Your Ref: OWPC20166
Our Ref: R/190/18/PL 31-07-2018
Please ask for:
Mrs A Gardner

Demolition of 1 No. existing house & grounds & erection of 2 No. new detached dwellings. This application may affect the character & appearance of the Station Road, East Preston Conservation Area.

St Marys Close Hurst Road Rustington

Thank you for your internet representation made on 11th October 2018 which has been recorded as '**an objection**' with the comments as follows:

Drawing Title:
ADDITIONAL DWELLINGS
BLOCK/ SITE PLAN

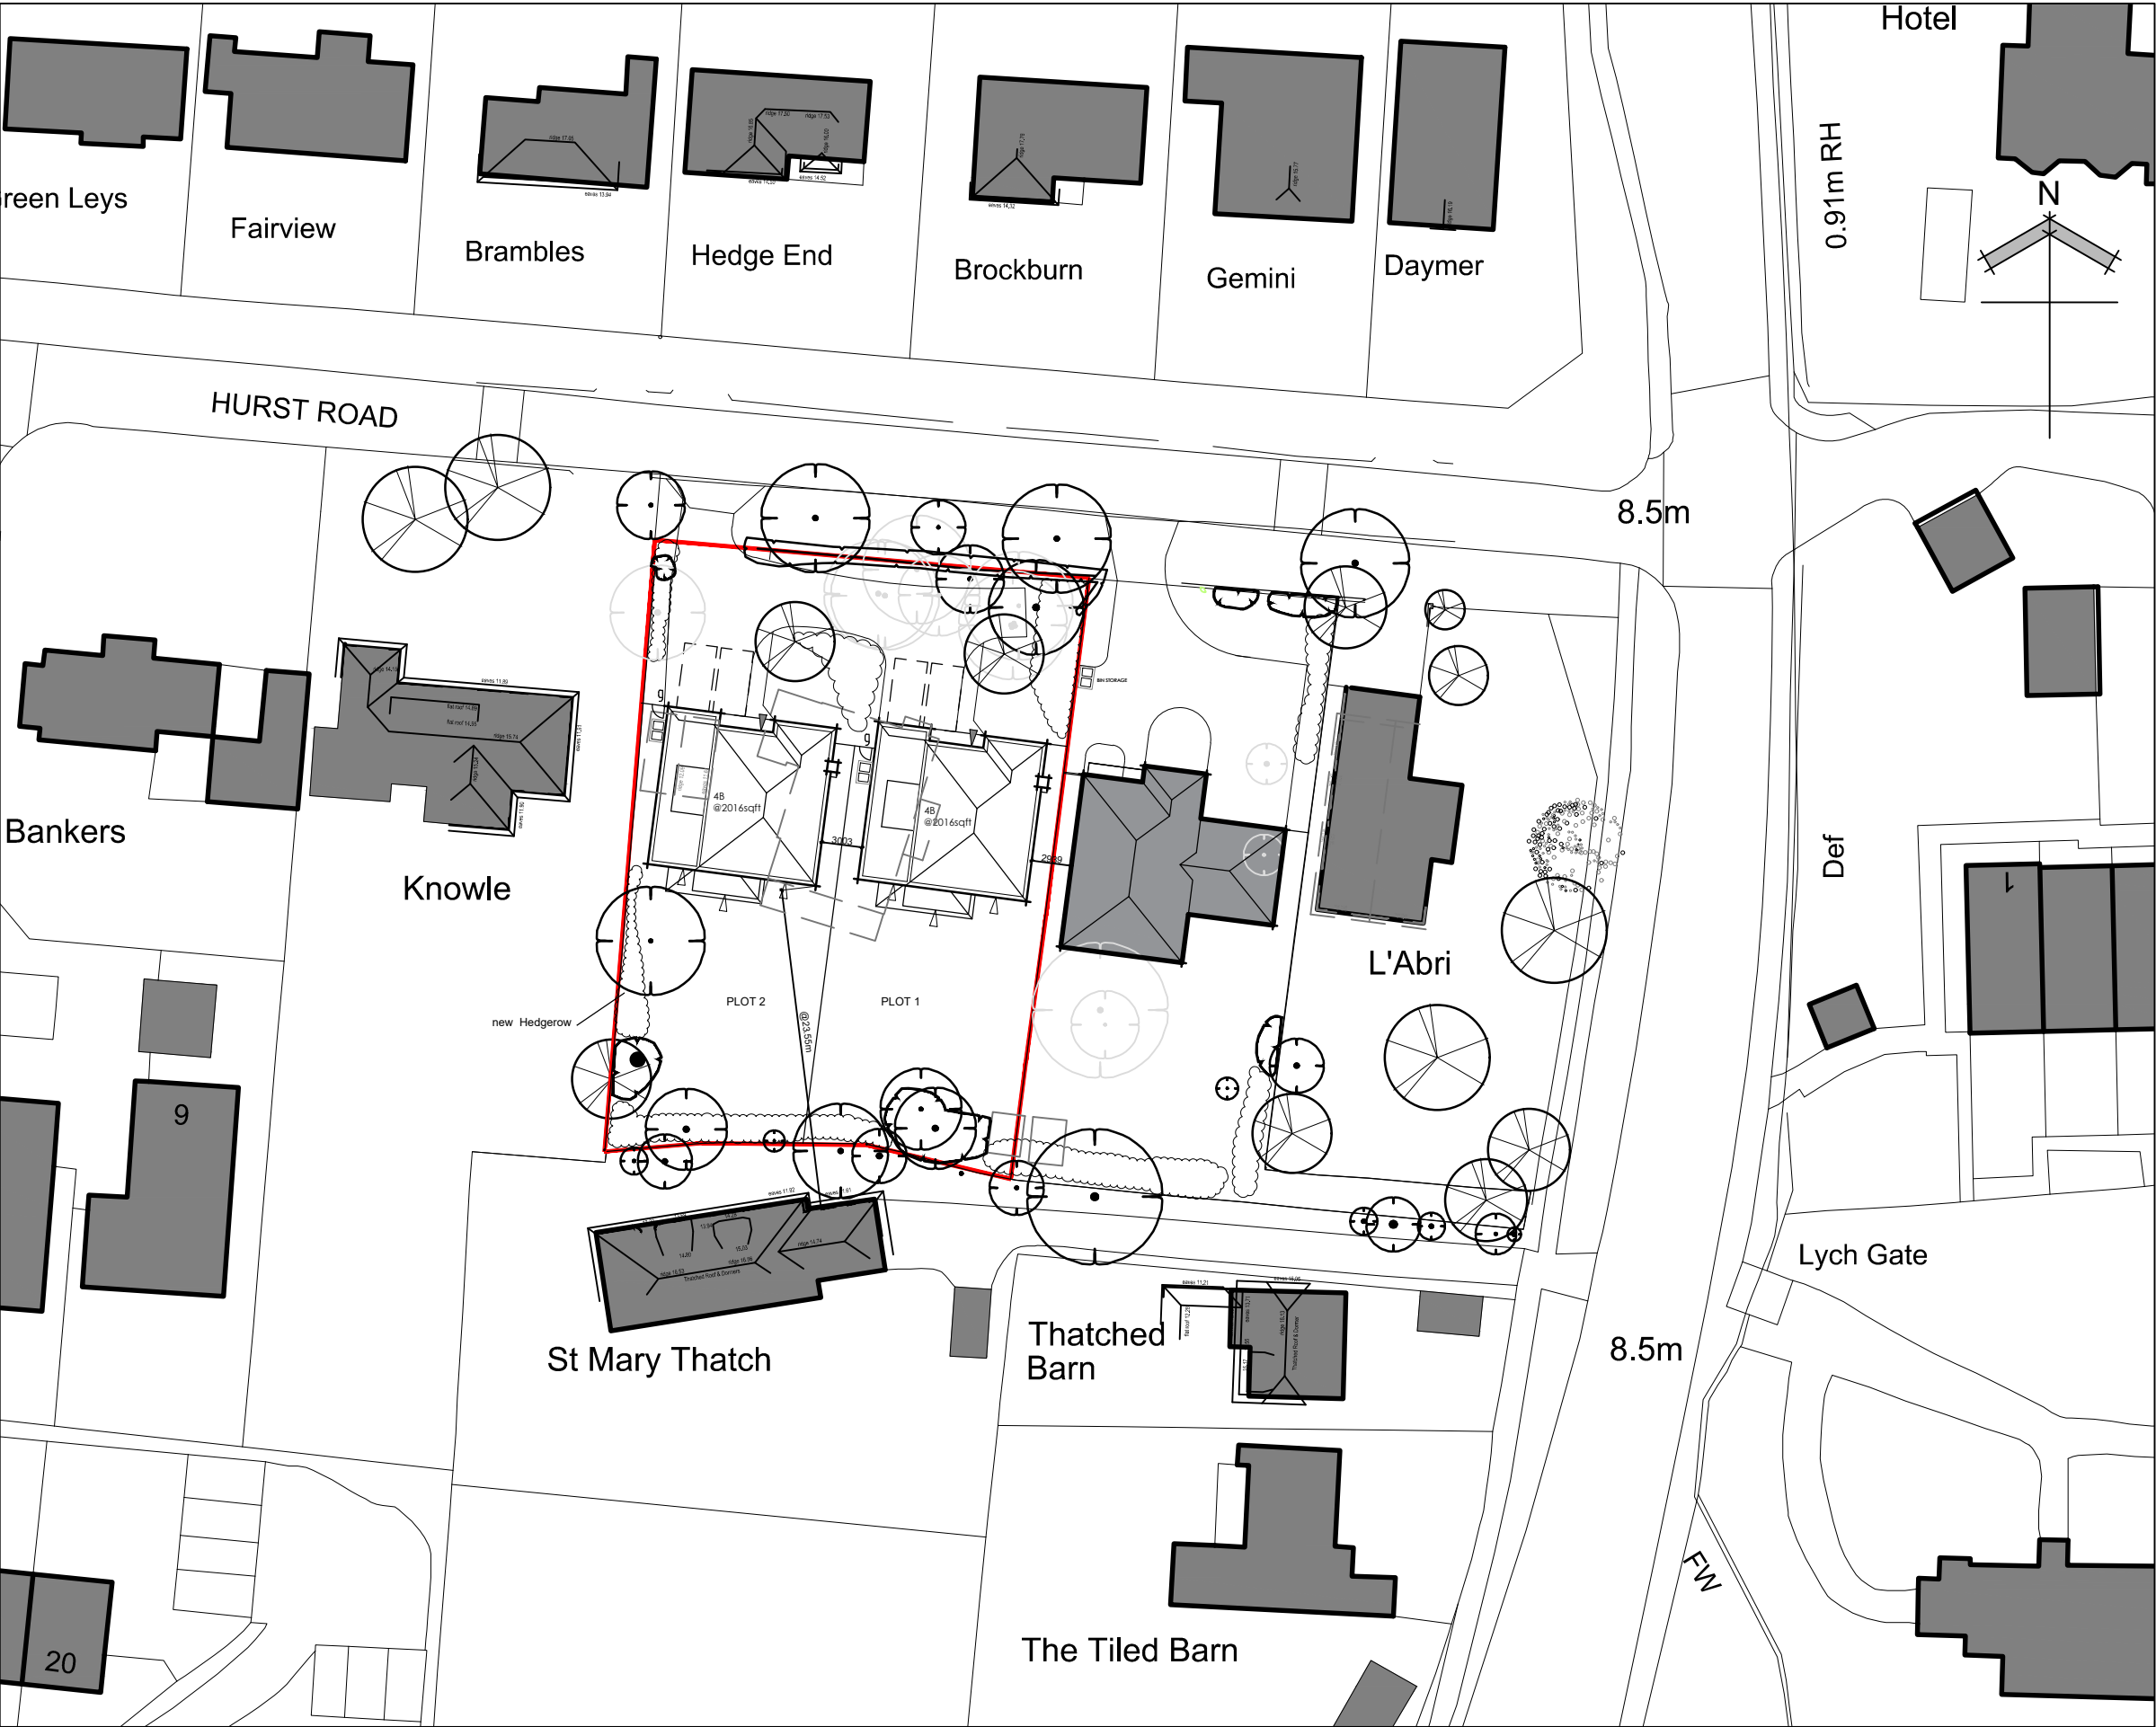
We would also ask that they ensure sufficient parking as the road is narrow and there is a requirement for emergency vehicles to reach the sheltered housing at the end of the road. The existing residents have an agreement not to park on the road for this purpose.

Drawing Title:
ADDITIONAL DWELLING
PLOTS 1 & 2
ELEVATIONS

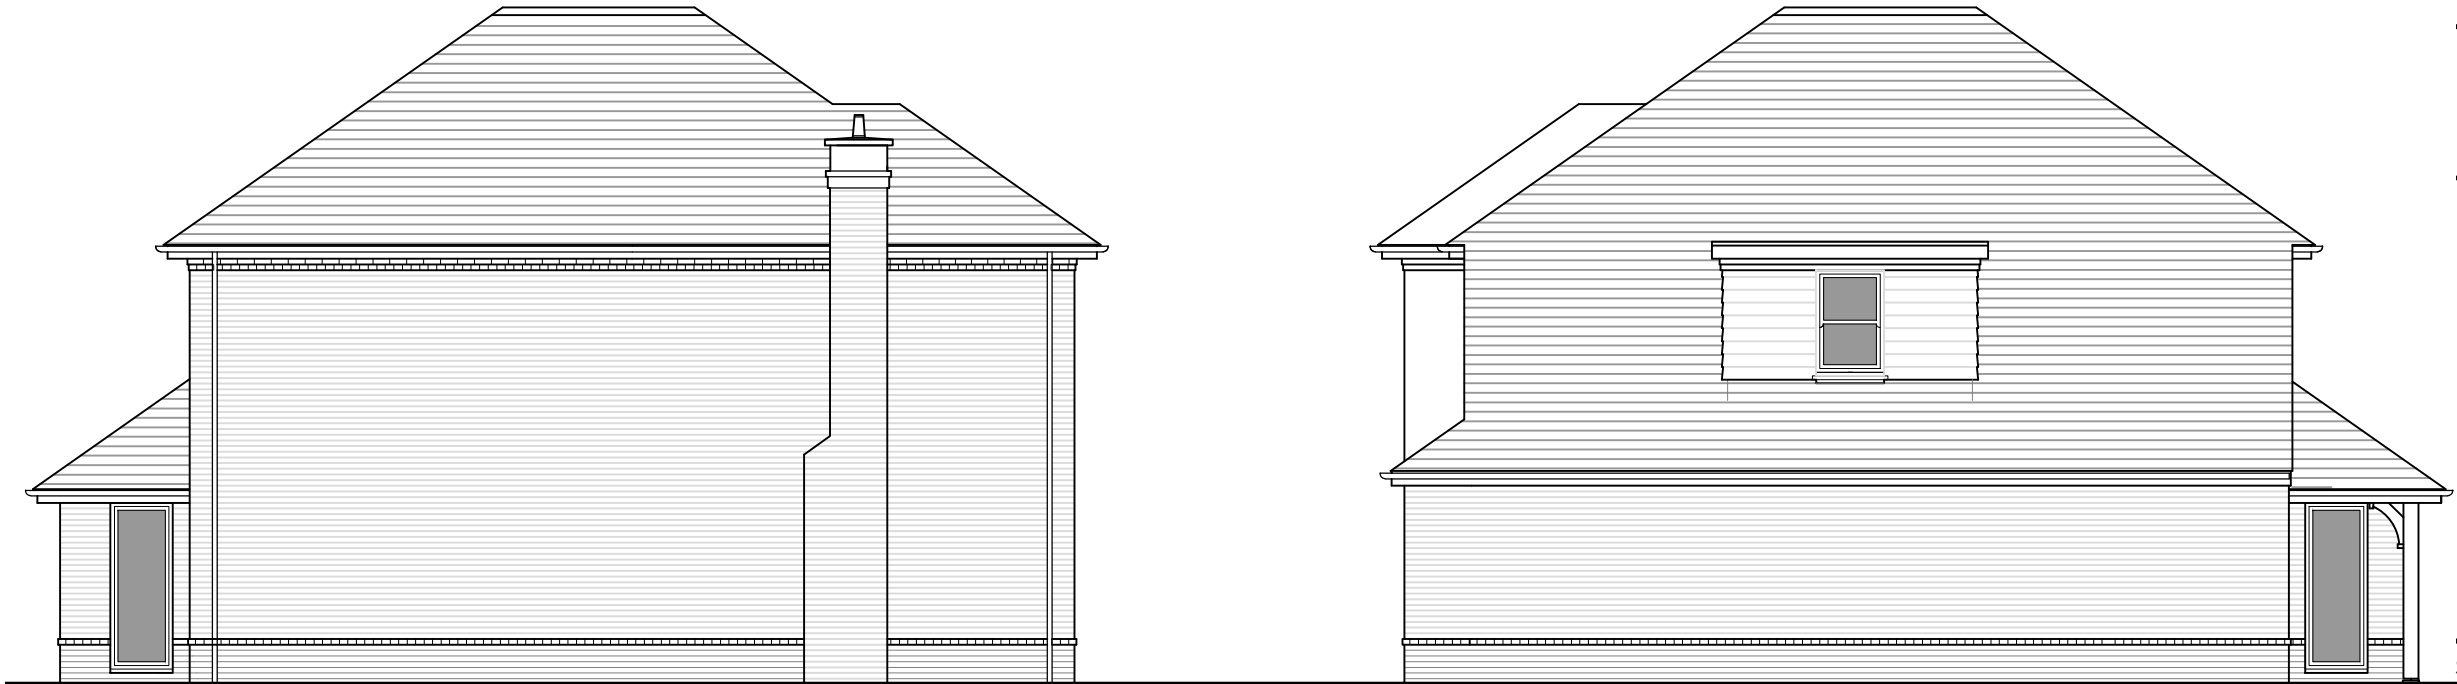
We do not object in principal to MJH building two properties on this site as this would be in keeping with the overall housing density for the road. However we do object to the houses being identical. The road has a diverse collection of houses and each is unique. We would like the developer to build two different designs to maintain the character of the road. In our opinion just covering the houses with different facings is not sufficient.
